70013258 -FRA Addendum P01

DATE:	11 June 2024	CONFIDENTIALITY:	Public
SUBJECT:	WSP Response to LLFA comments		
PROJECT:	Land East of Westergate, Aldingbourne. Ref 70013258	AUTHOR:	Julien Blavignac
CHECKED:	Luke Beeching	APPROVED:	Luke Beeching

WSP RESPONSE TO LLFA COMMENTS

This addendum has been prepared in response to comments raised in the objection submitted by West Sussex County Council Lead Local Flood Authority (LLFA) dated 3rd of April 2024 in relation to the Flood Risk Assessment and Drainage Strategy issued as part of the outline planning application AL/11/24/OUT - Land East of Westergate, Westergate.

Client	Cala Homes South Home Counties		
Job no.	CALA230719	Date	31.07.23
Dwg no.	DPDPP-01	Rev.	A
Author	PM/AA	Checked	HM/-
Status	PLANNING	Scale	1:2500@A3
		Office	Romsey

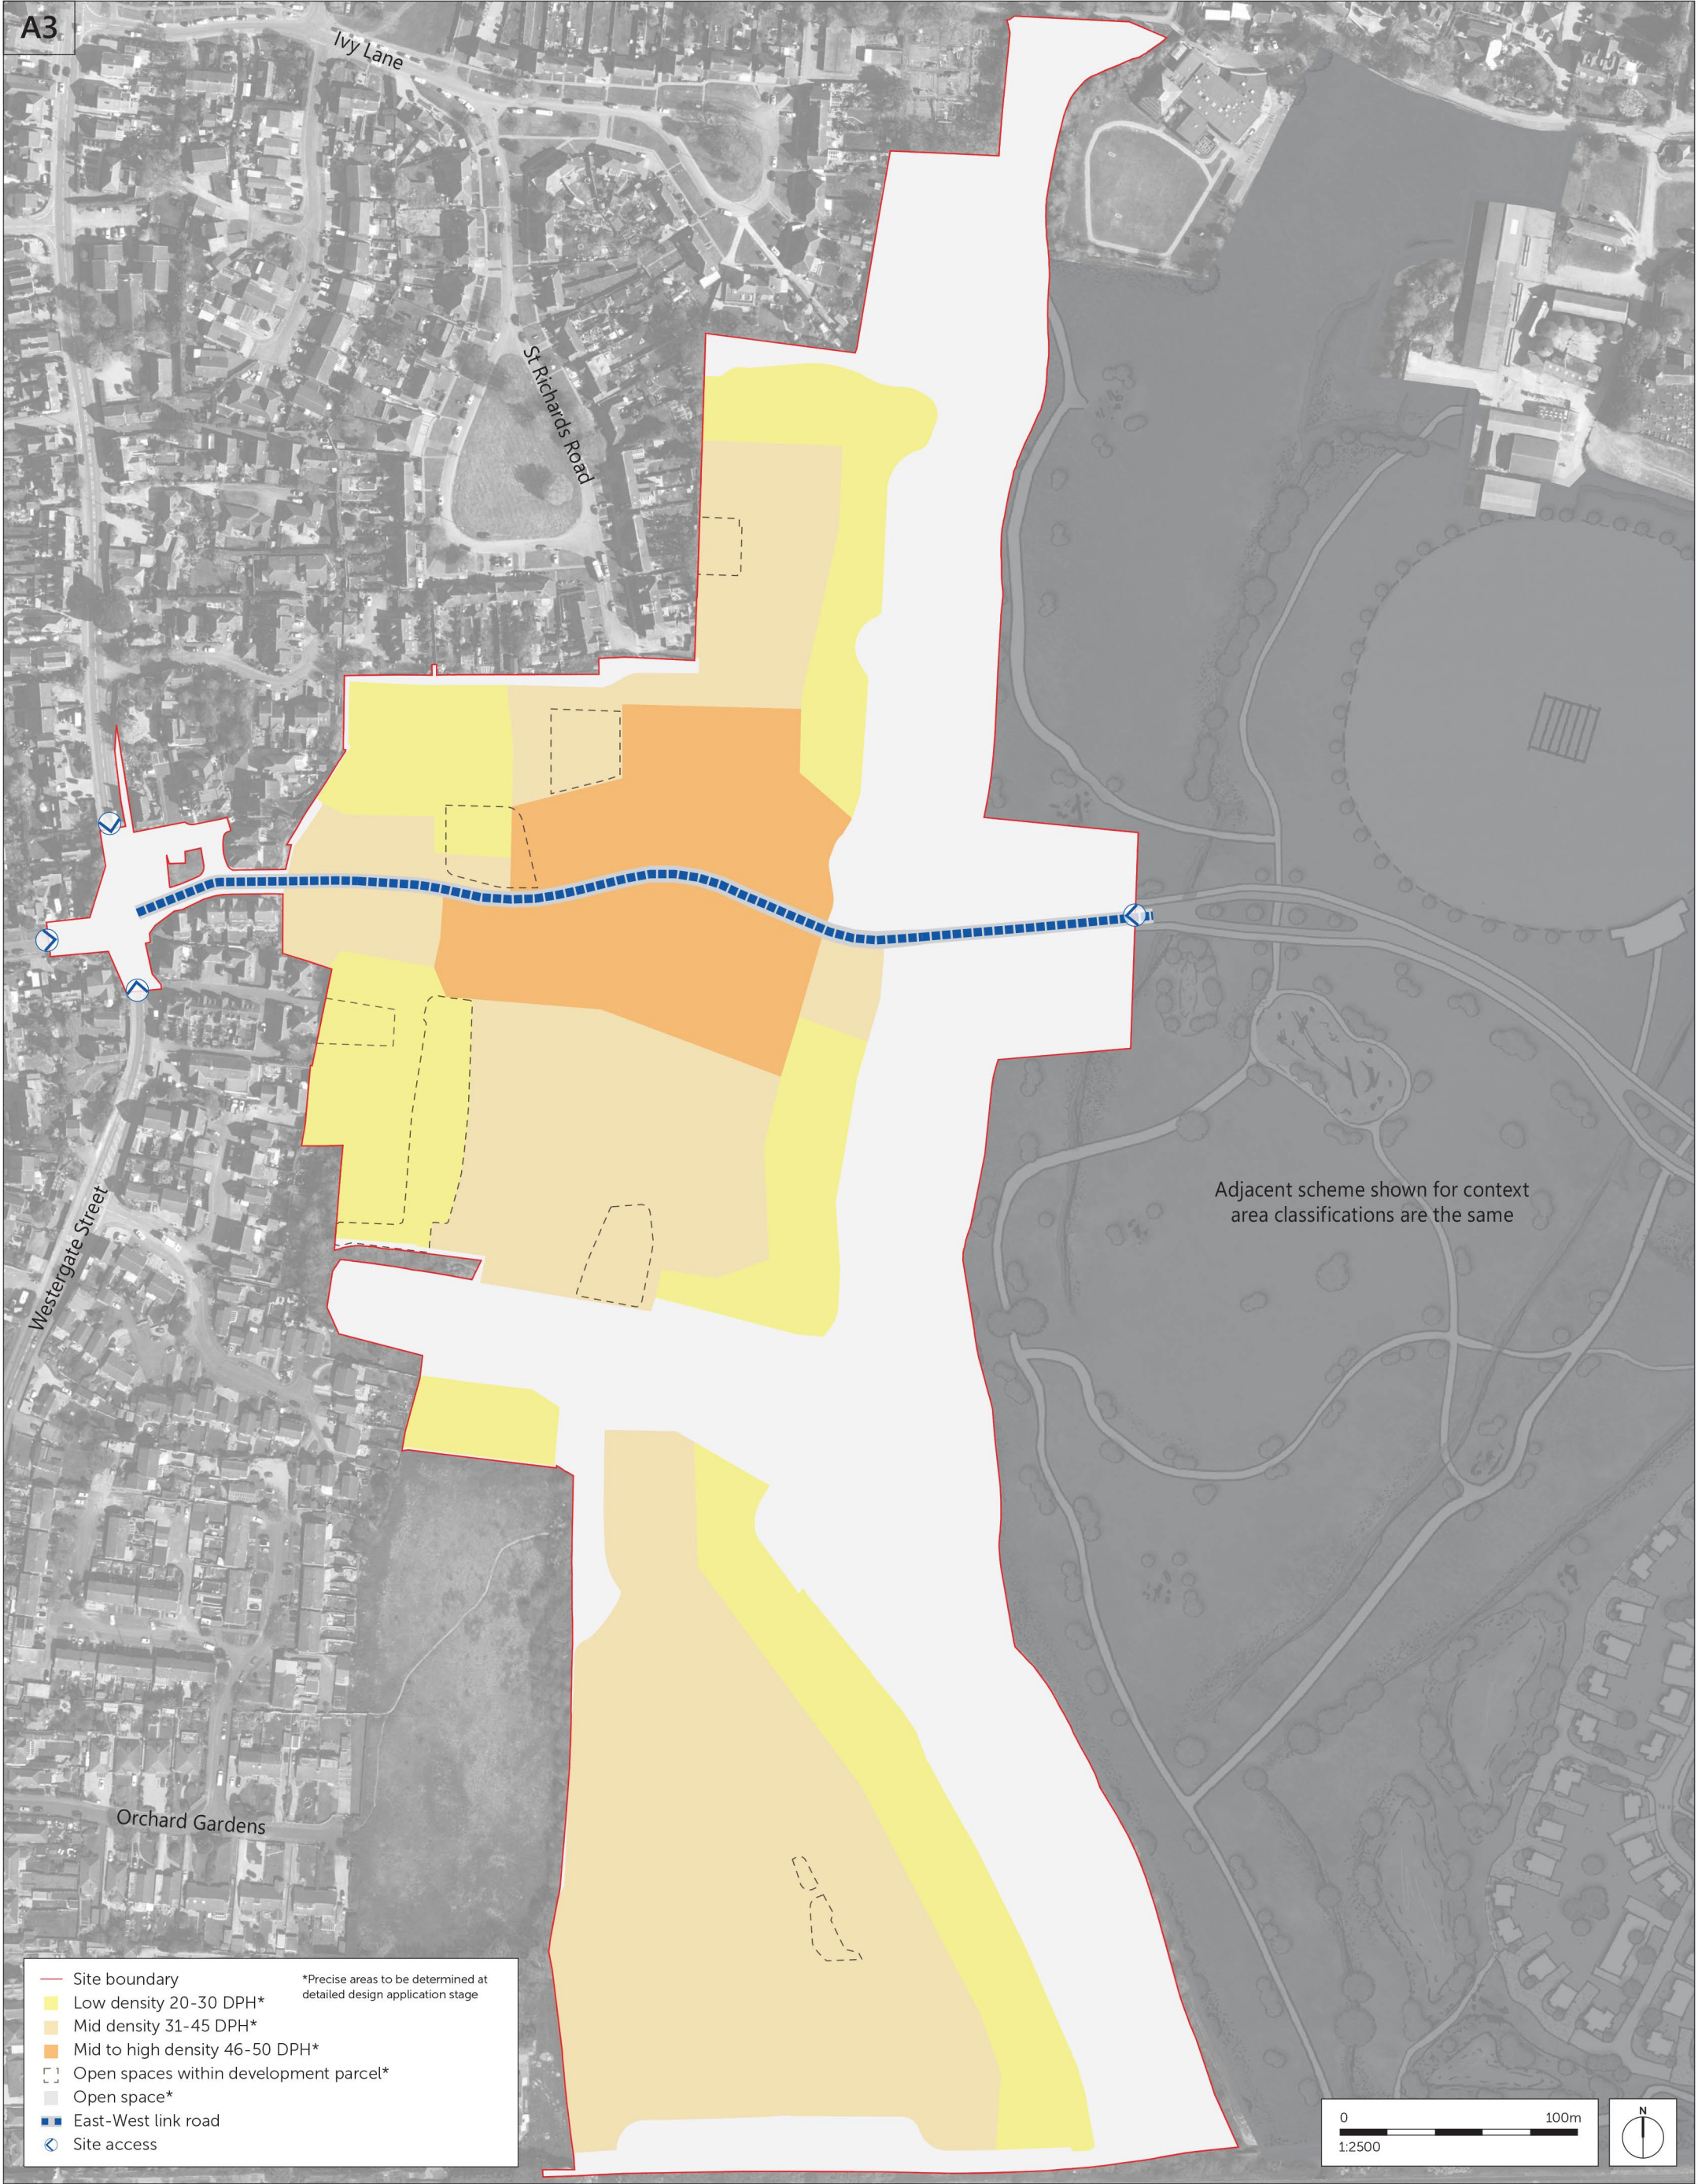
2.Outline drainage modelling calculations should be resubmitted and demonstrate how 10% urban creep has been included in the volume of SuDS storage required.

Included in Appendix B is a copy of Thrive Architects Plan Ref DPDPP-01 showing the Development Parcels and Density Parameter Plan (dated 31.07.23) Rev A.

This plan shows that the 10% allowance is only valid for the low density category which represents only a small portion of the site.

Most of the site is identified for Mid Density (31-45 dph) where a 6% allowance would be more appropriate.

The proposals also include an area of mid to high density (45-50 dph) where the potential for urban creep is limited and a 2% to 4% allowance would be appropriate.

Based on the above, an average allowance of 6% has been used for the overall site at this stage of outline planning.
